CITY OF ALBUQUERQUE

October 18, 2022

Re: Harper Apartments (PHASE 2)/ 6100 Harper Pl. NE
Request for Certificate of Occupancy
Transportation Development Final Inspection
Architect's Stamp dated 09-15-2020 (E18-D016)
Certification dated 10-07-22

RE: Request for Certificate of Occupancy – Phase 2
TCL
Plan dated 10/22/07
Administrative Amendment

TRAFFIC CIRCULATION LAYOUT
 APPROVED

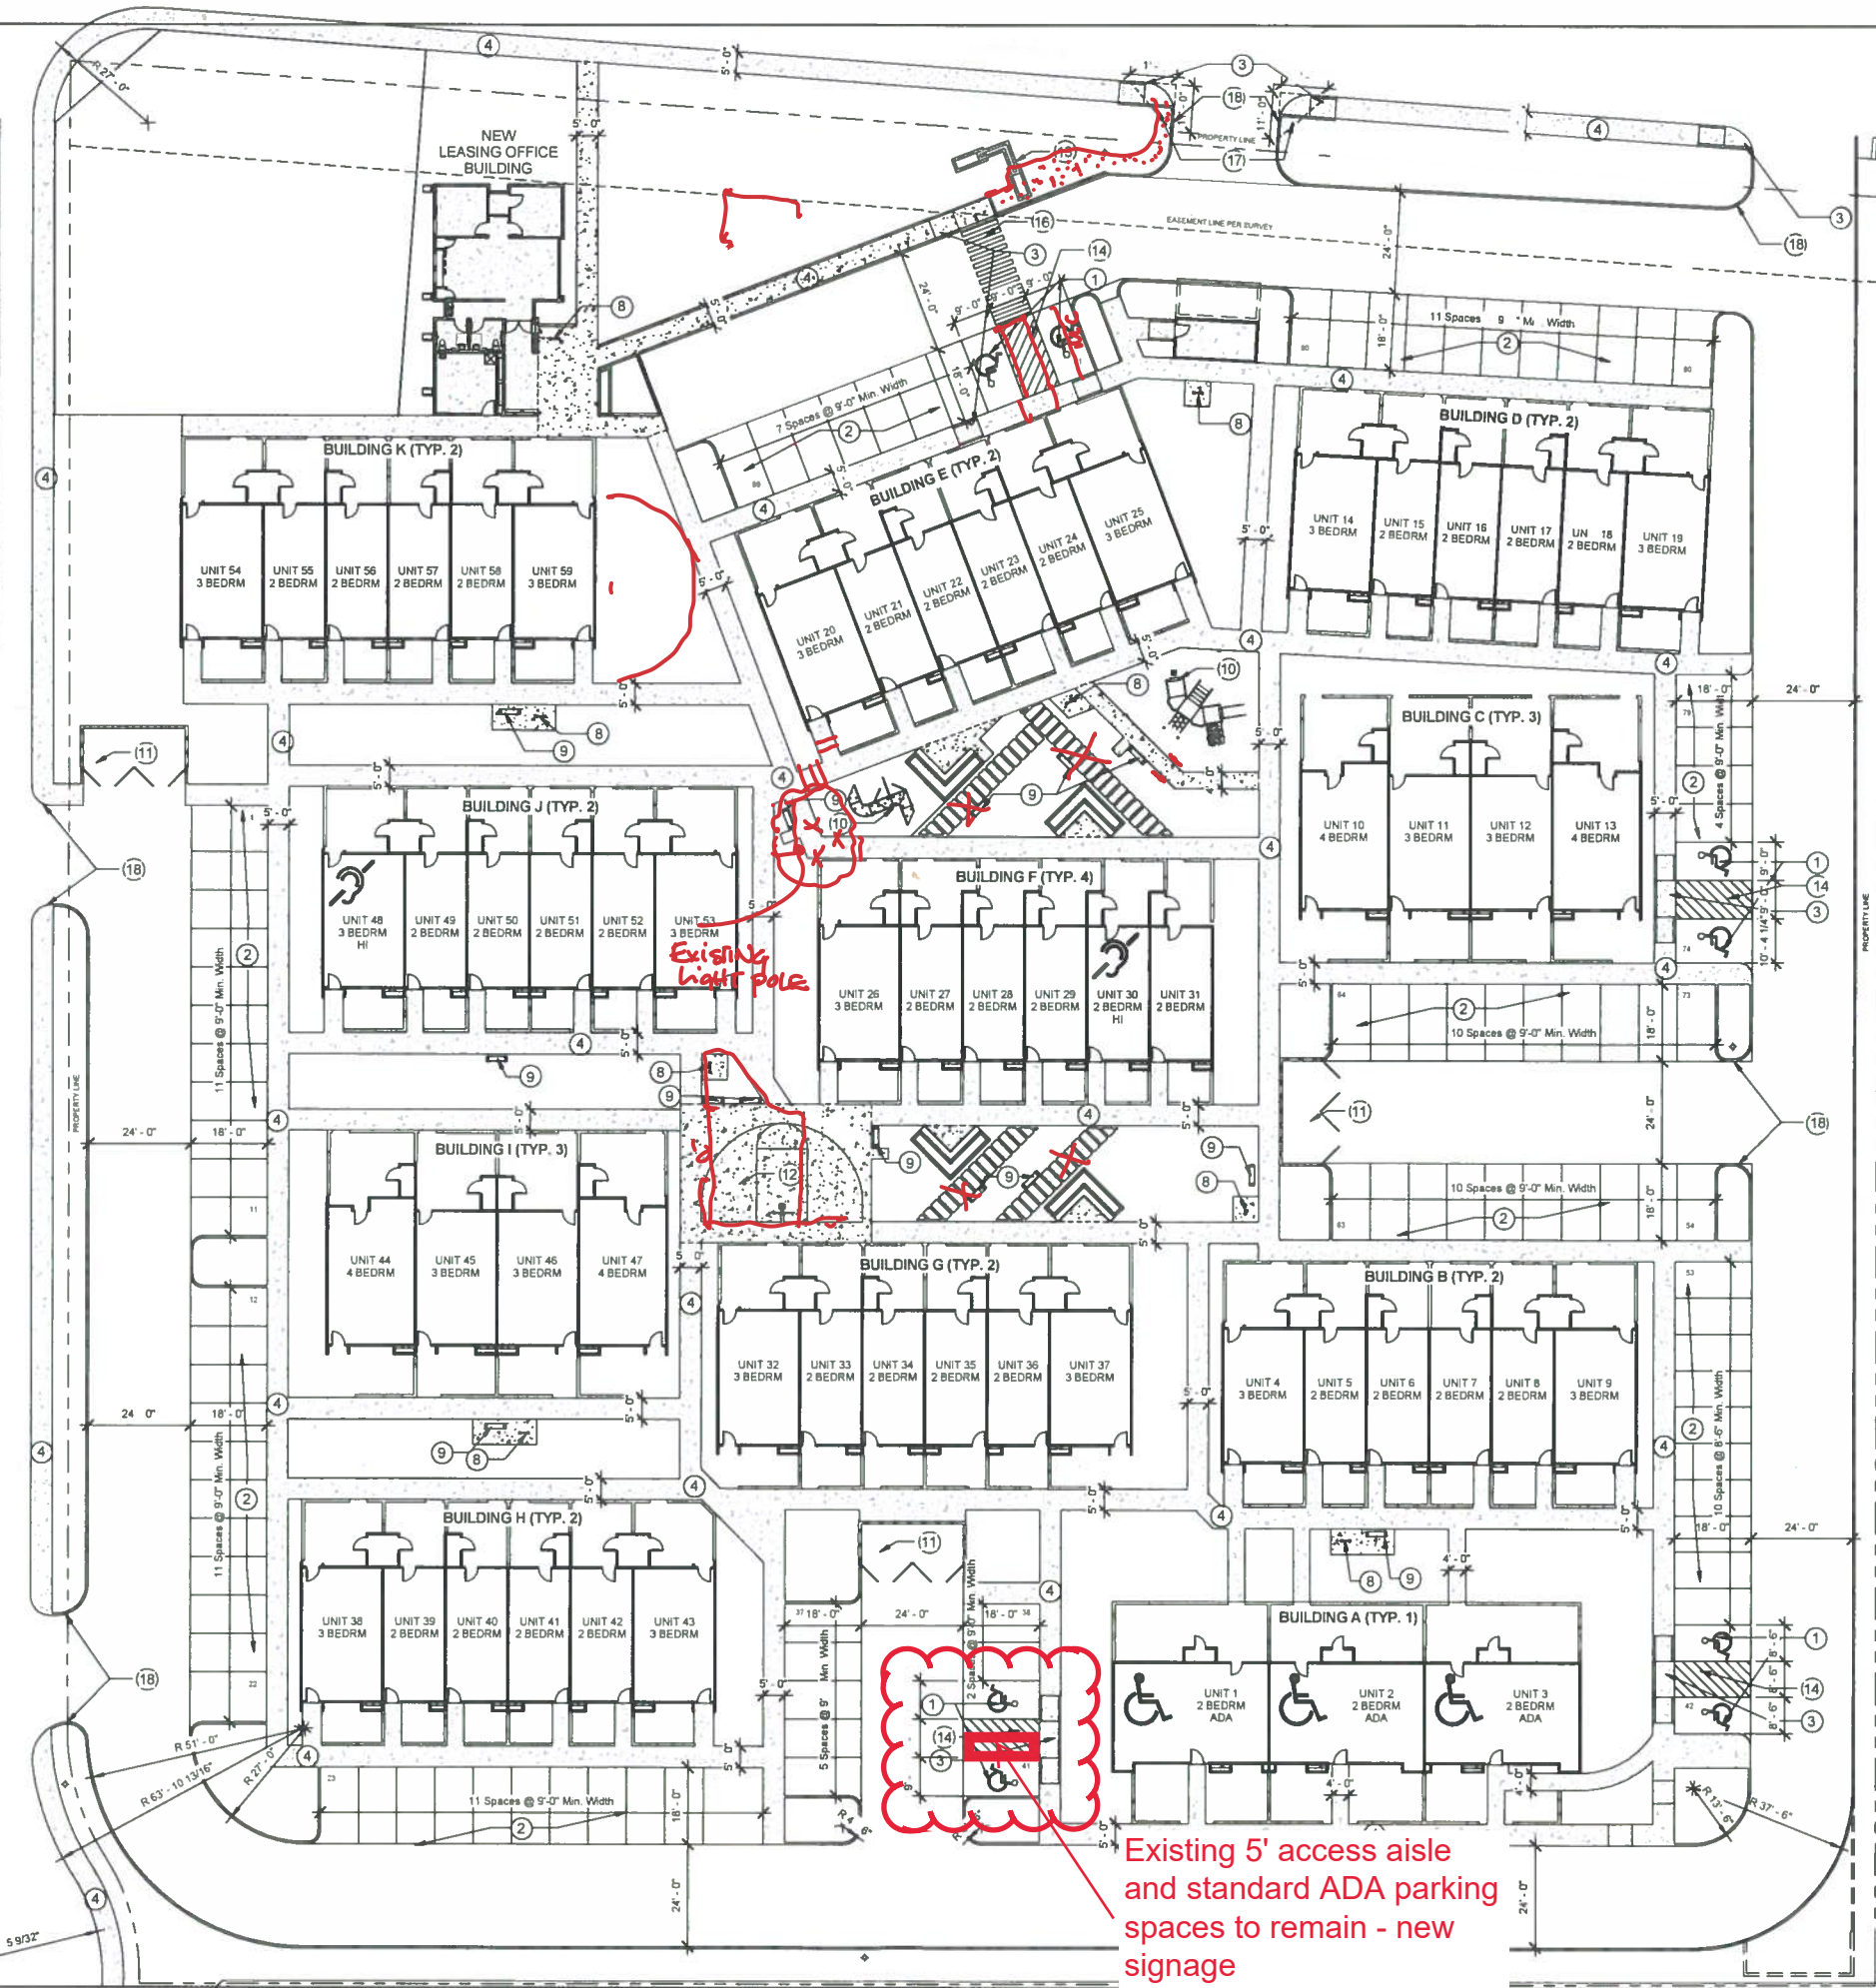
- In accordance with NMBC-2015, the minimum number of van accessible parking spaces for the property would be 1, as there are 99 parking spaces available. The property prior to renovation included 1 van accessible space. A second was added in Phase 1 of the work, more than meeting the minimum requirement. To ensure that an accessible space could be provided in this current phase while granting access to the Community Building, the access aisle was adjusted to 5 feet. This did two things: it created space for a motorcycle parking space, and it allowed the curb ramp to be positioned so as to not interfere with the existing back yard gates. The access aisle as constructed is compliant with ADA and ANSI and would not be required to be van accessible. As such, the contractor is removing the “van accessible” sign from this space.

- The subsequent motorcycle parking space resulting from the above change will receive a parking sign. This will be installed as well.
- Disturbed areas were noted and I am assuming that what was described was the area between Buildings E and F. The phasing plan has been revised to show this area to be completed with Building F. It will be fenced off as a construction site to protect the residents of Building E.

- The sidewalk at the south of Building E described to be completed was never a sidewalk. I have attached a photo to show the condition. There is an existing tree and light post precisely where the sidewalk would have continued. No plans were ever given to relocate the tree or the light post and this section of sidewalk was shown as “existing” on the TCL plan. I have noted the plan accordingly.

There were some other modifications made to the site plan which I have also included on the attached noted TCL plan. The most notable of these is the continuation of the accessible route to the street north of Building E.
